OBJECTION

State Significant Development Application No: SSD-10300

Coffs Harbour Cultural and Civic Space

GORDON ST ELEVATION

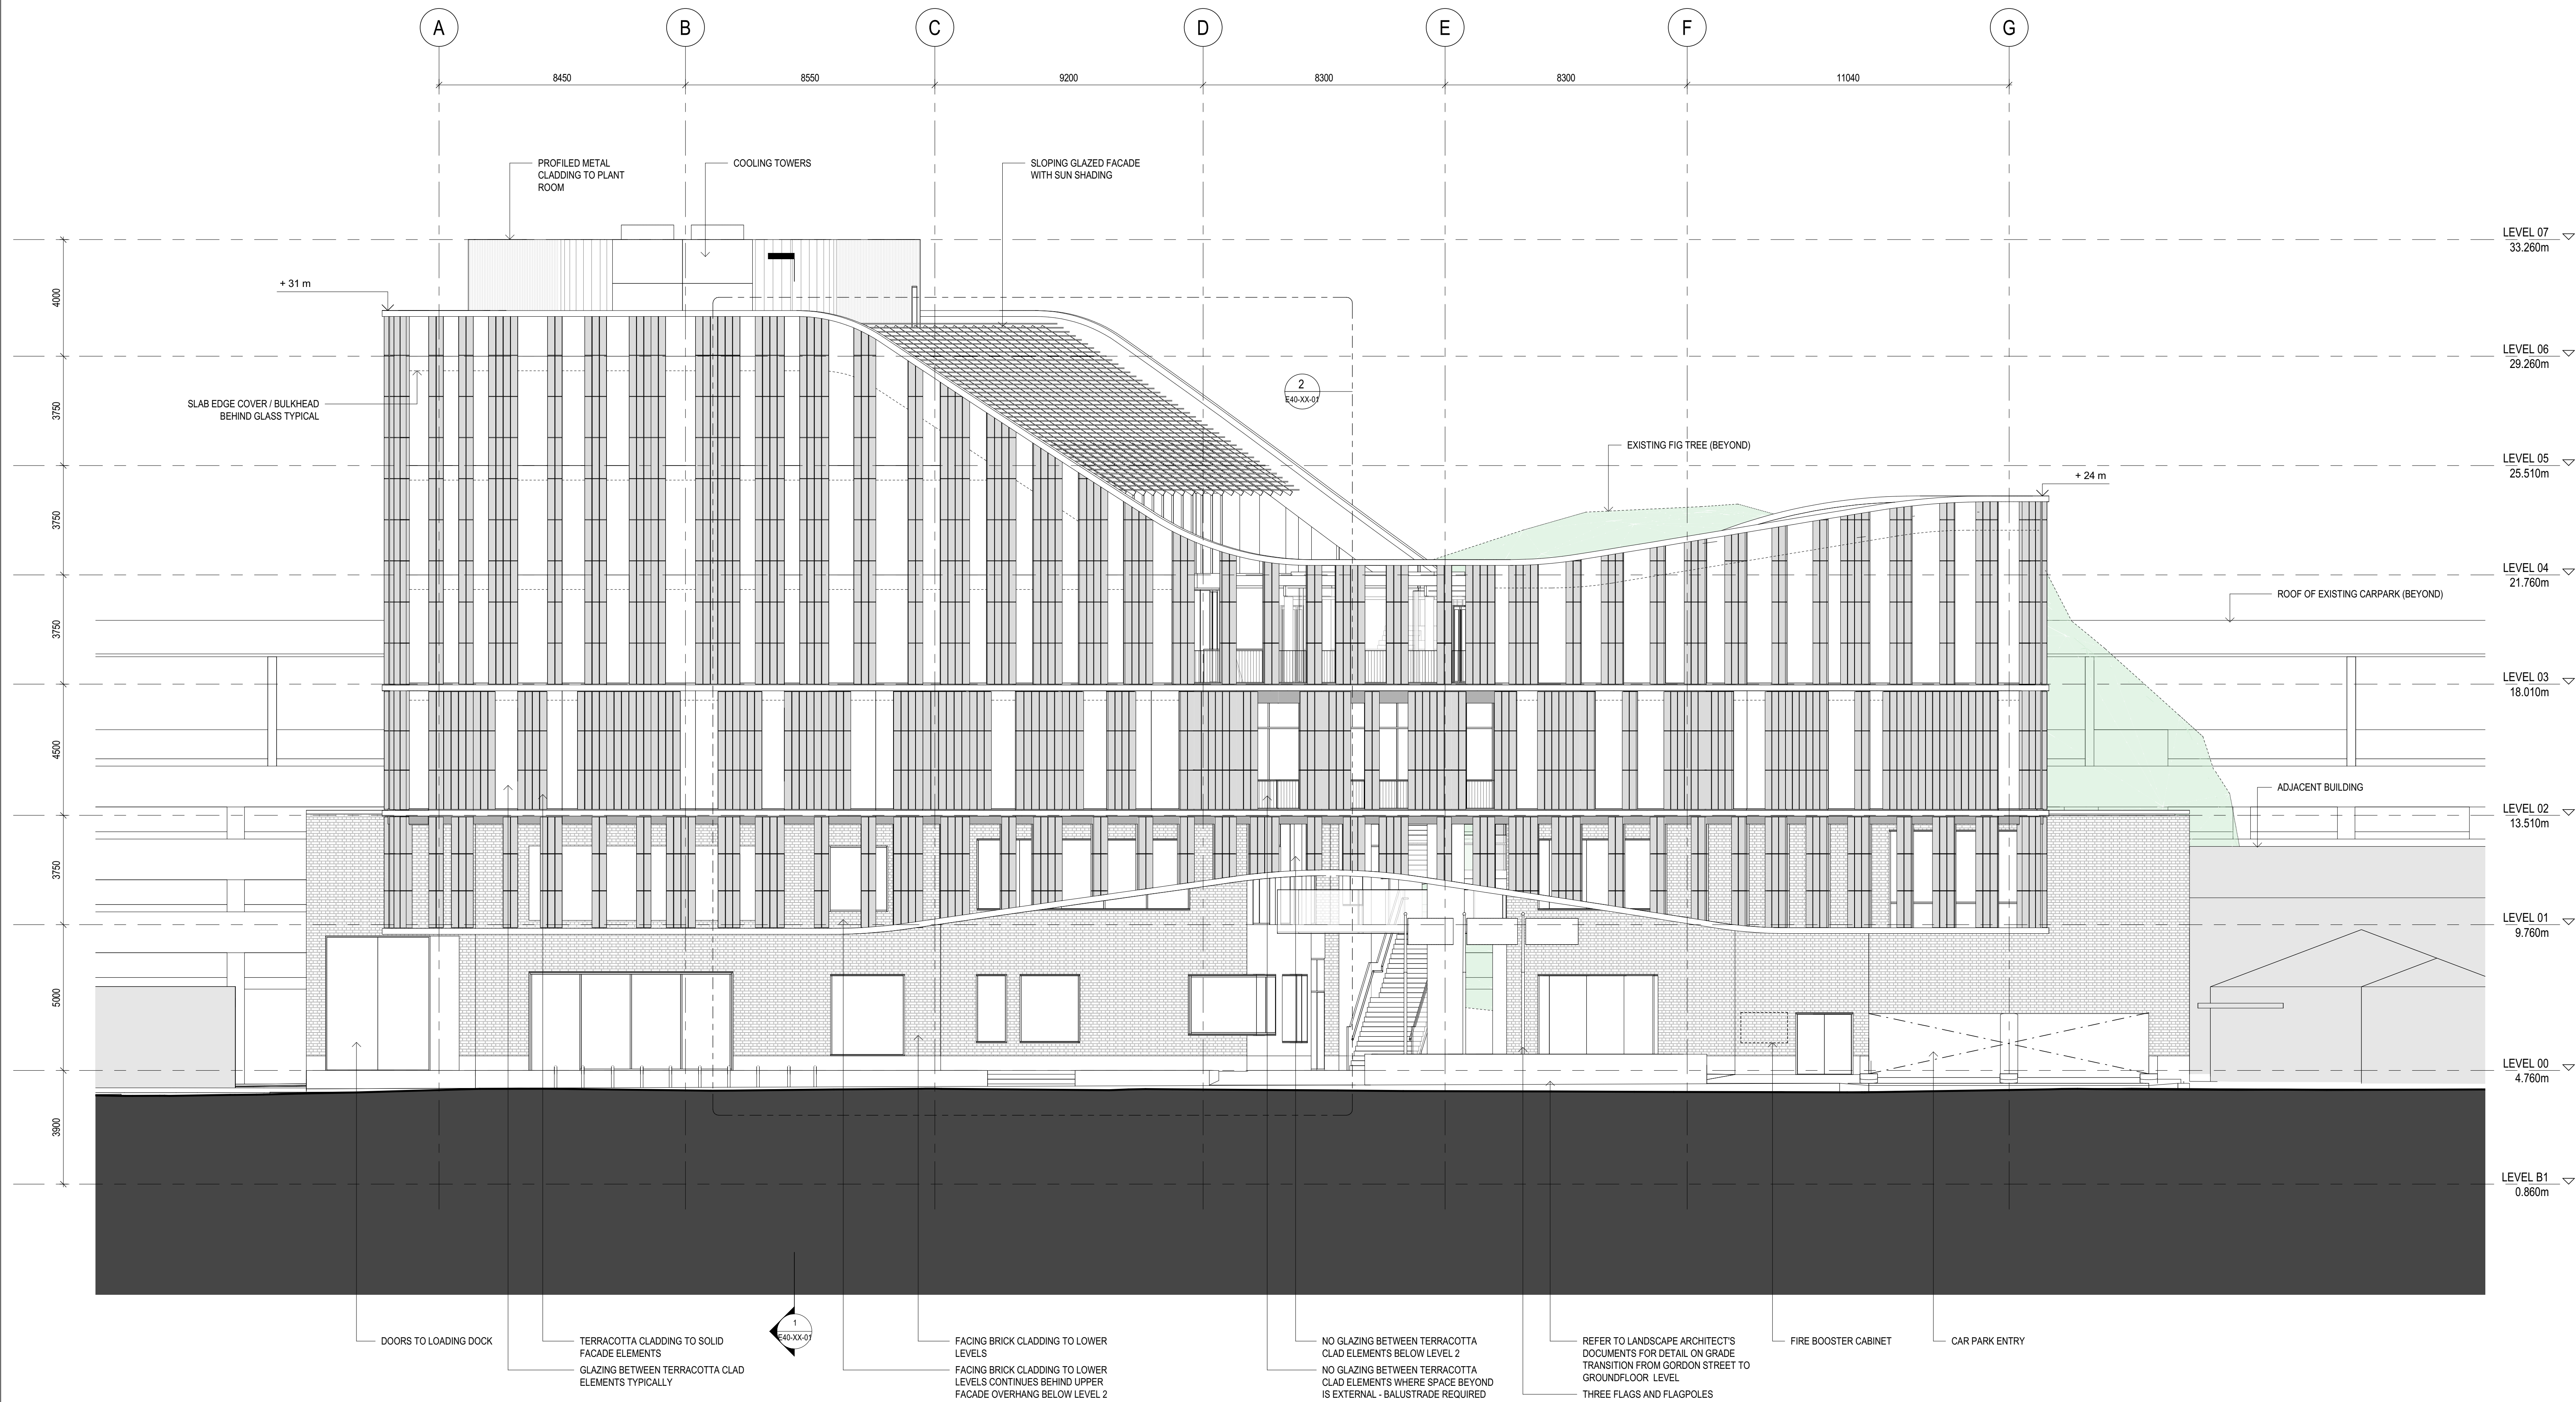
5. The proposed building is out of context in the street with no regard to scale, existing street setbacks, design and general form of adjoining buildings.

RIDING LANE ELEVATION

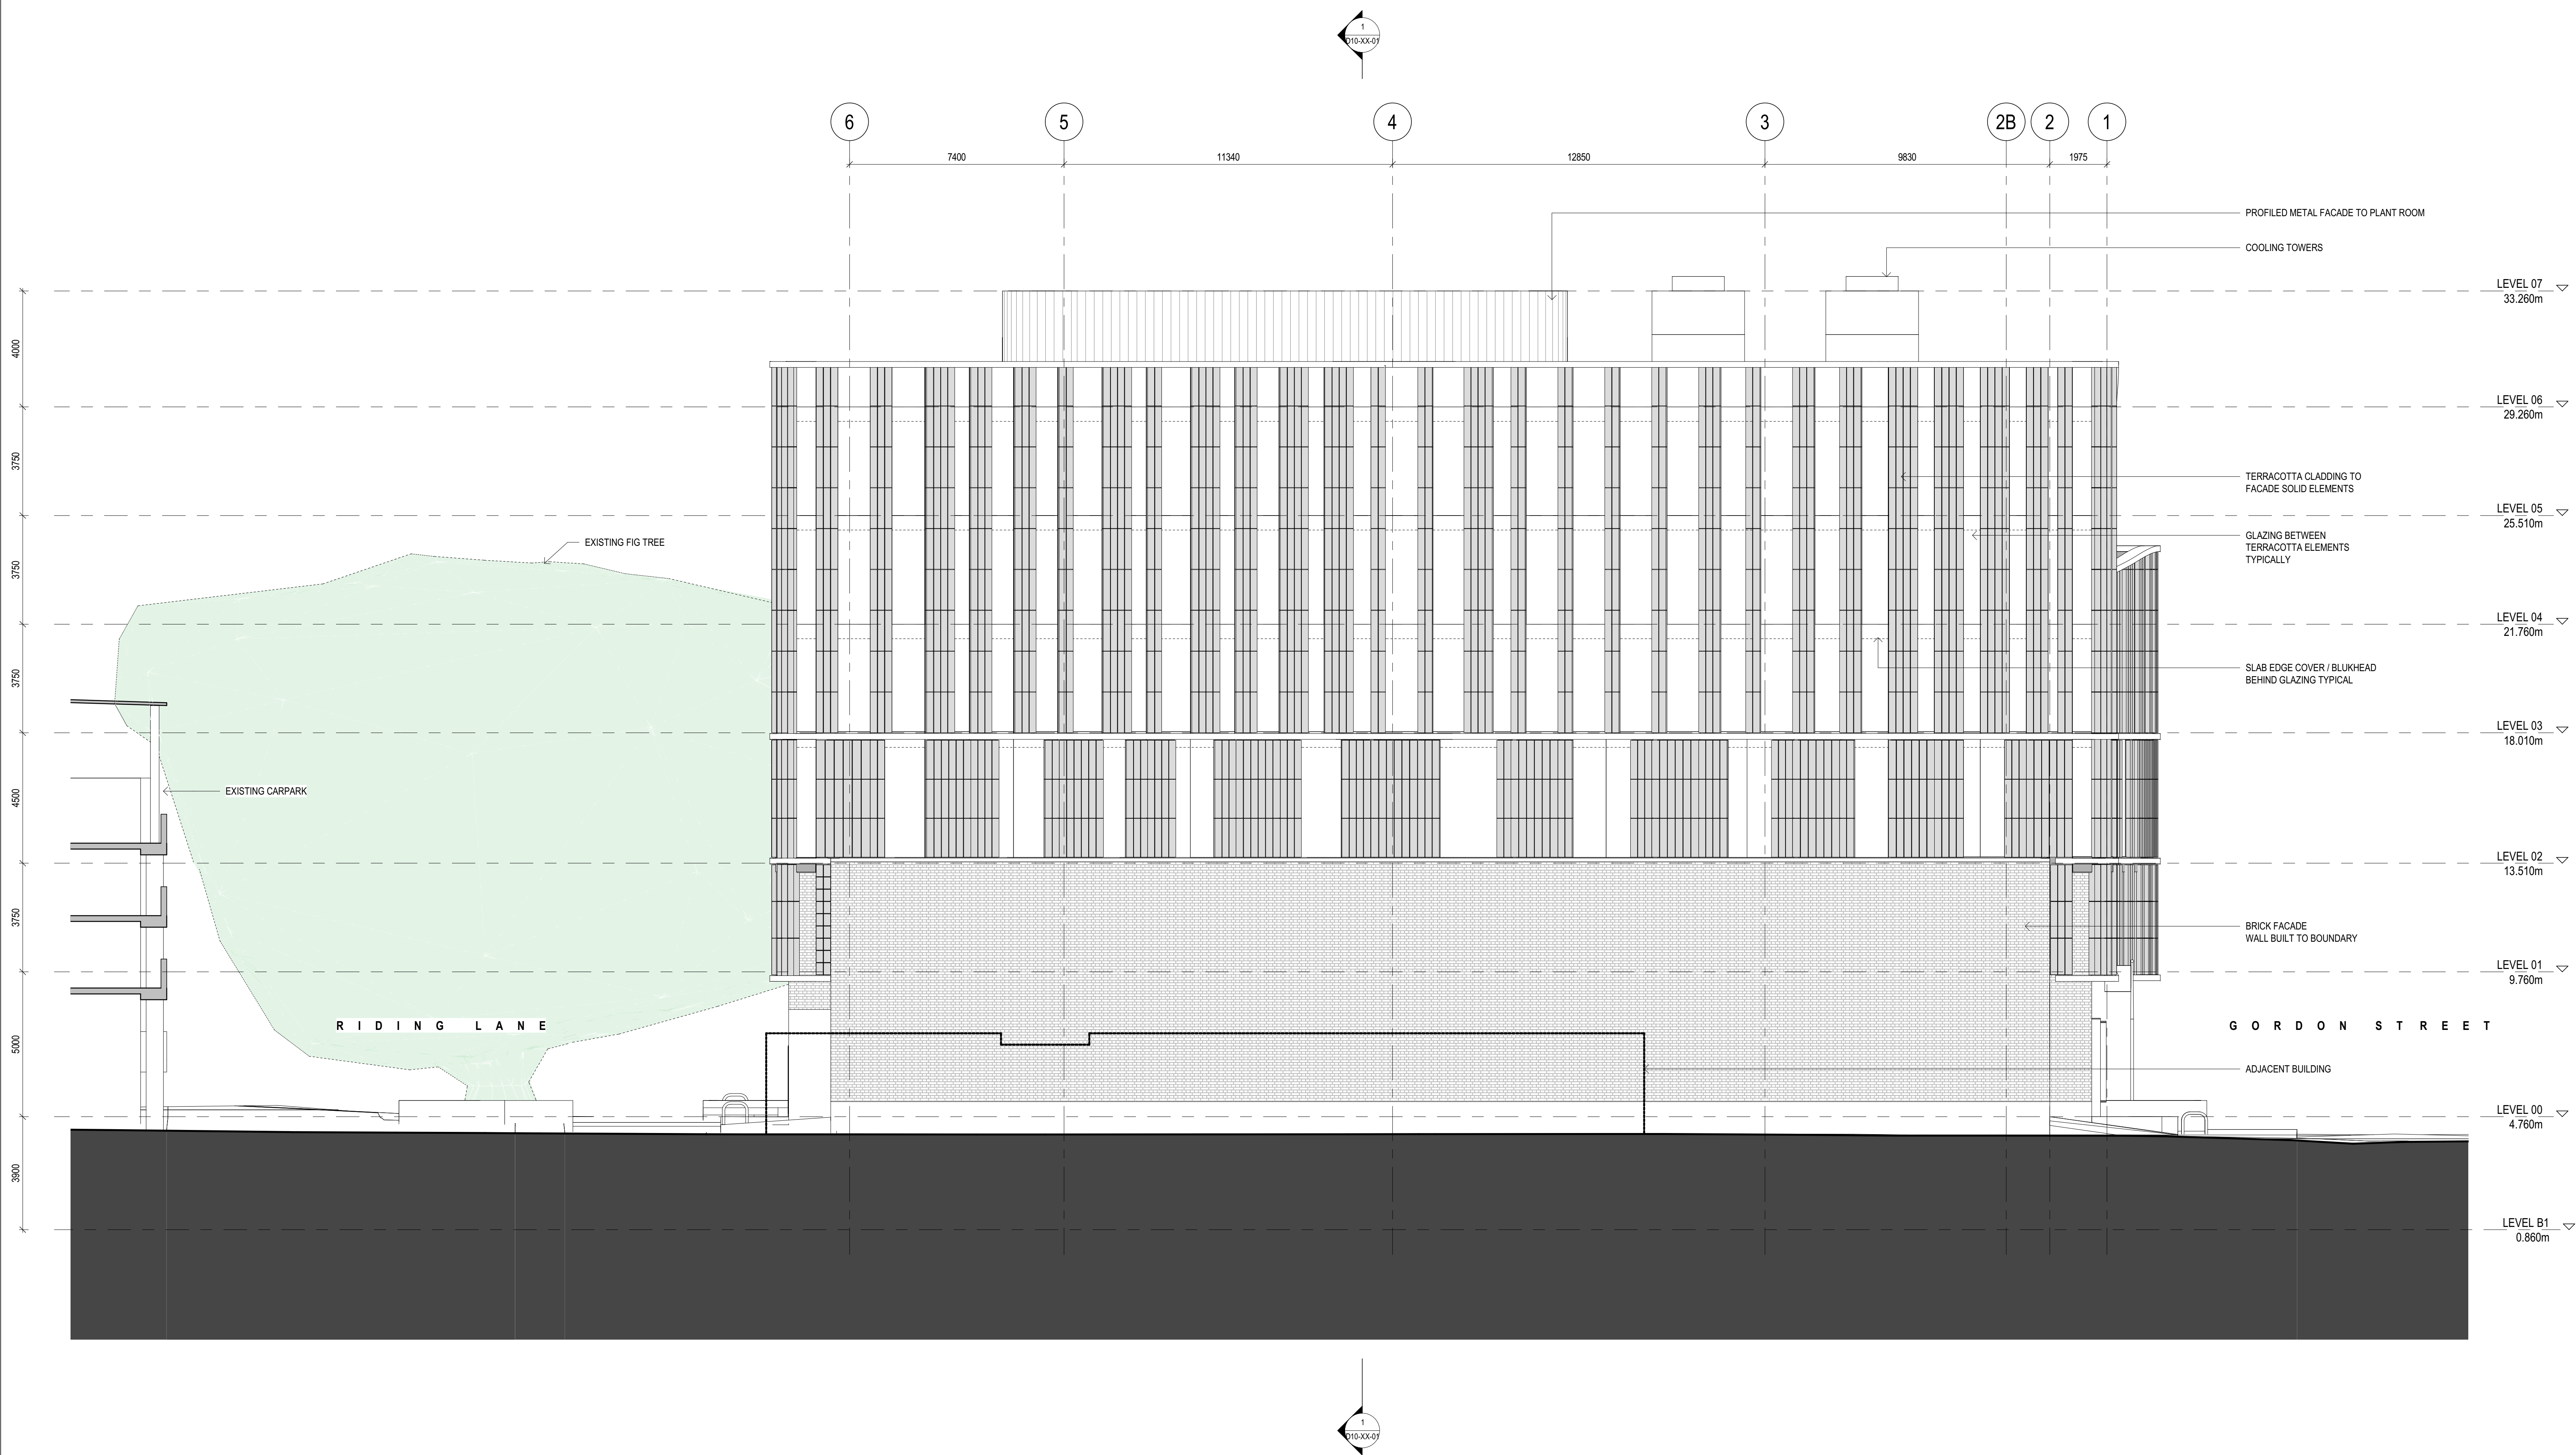
6. The proposal does not meet "safer by design" principles and guidelines, as the arcade to Riding Lane confuses boundaries and provides "hides" for criminal activity, vagrancy and prevents good surveillance.

NORTH ELEVATION

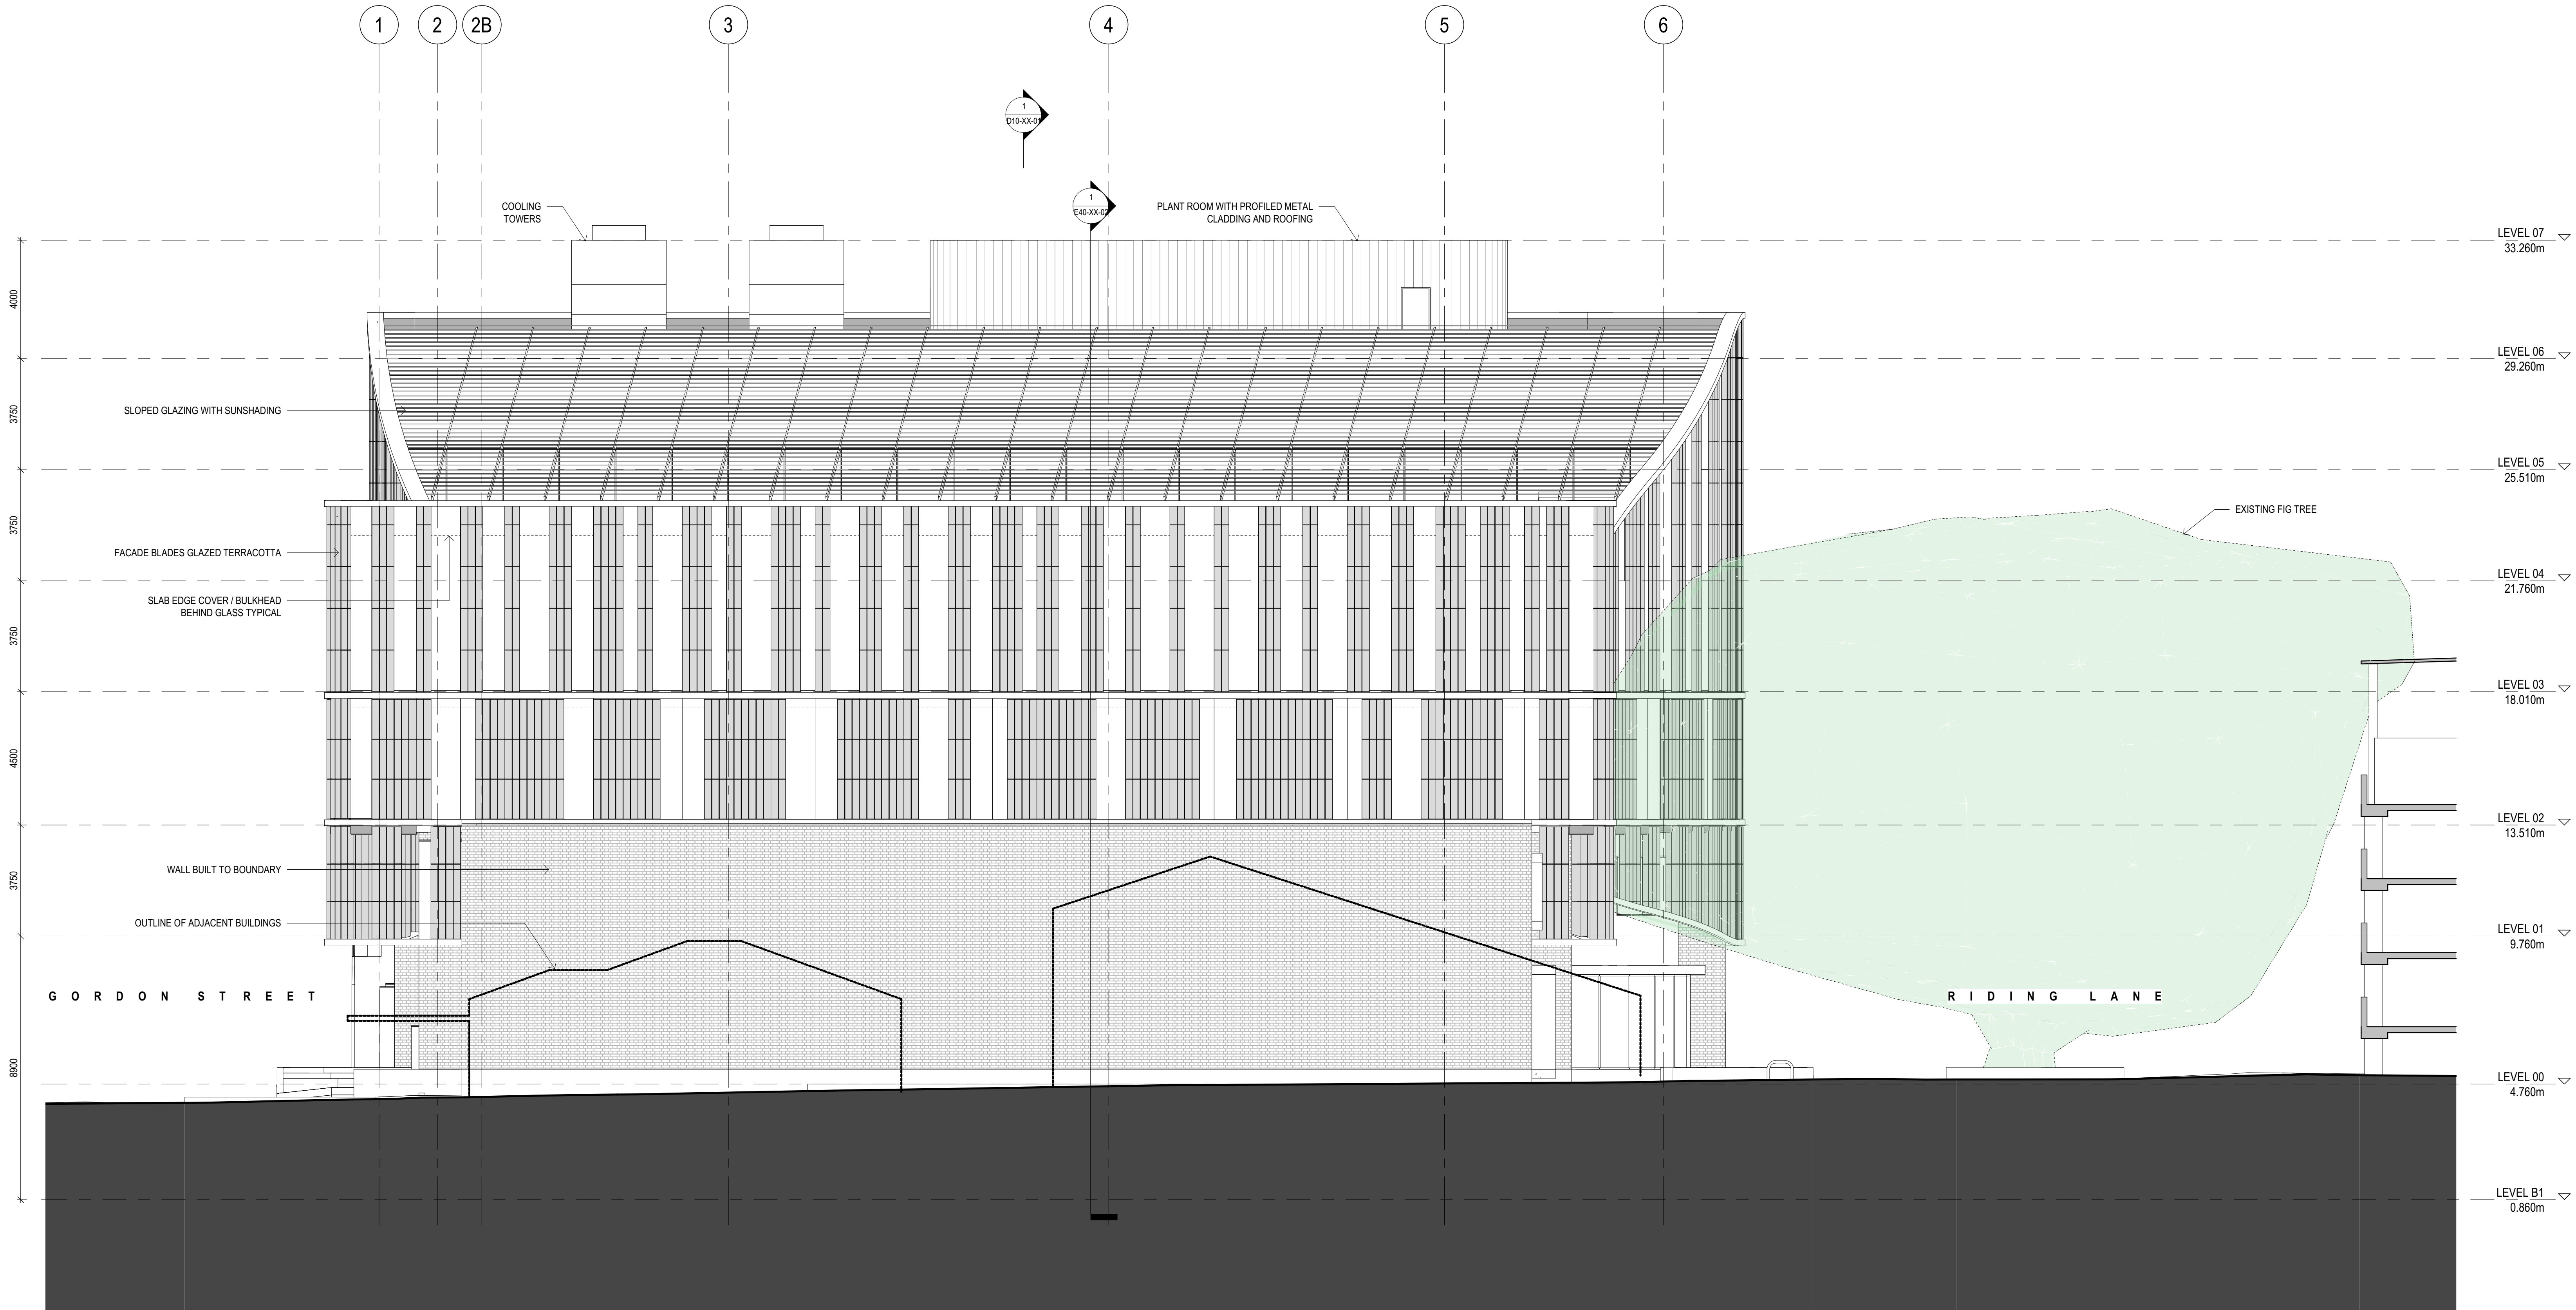
7. As a public building it fails to provide sufficient climate protection for pedestrians during storms and summer sun.
8. The building exceeds the height restriction of 28m set down in Council's own planning controls. Council's argument for variation is not satisfactorily justified and is not consistent with the objectives of the Environmental Planning and Assessment Act 1979, which requires the "the orderly and economic use and development of land". Council should not receive preferential treatment.
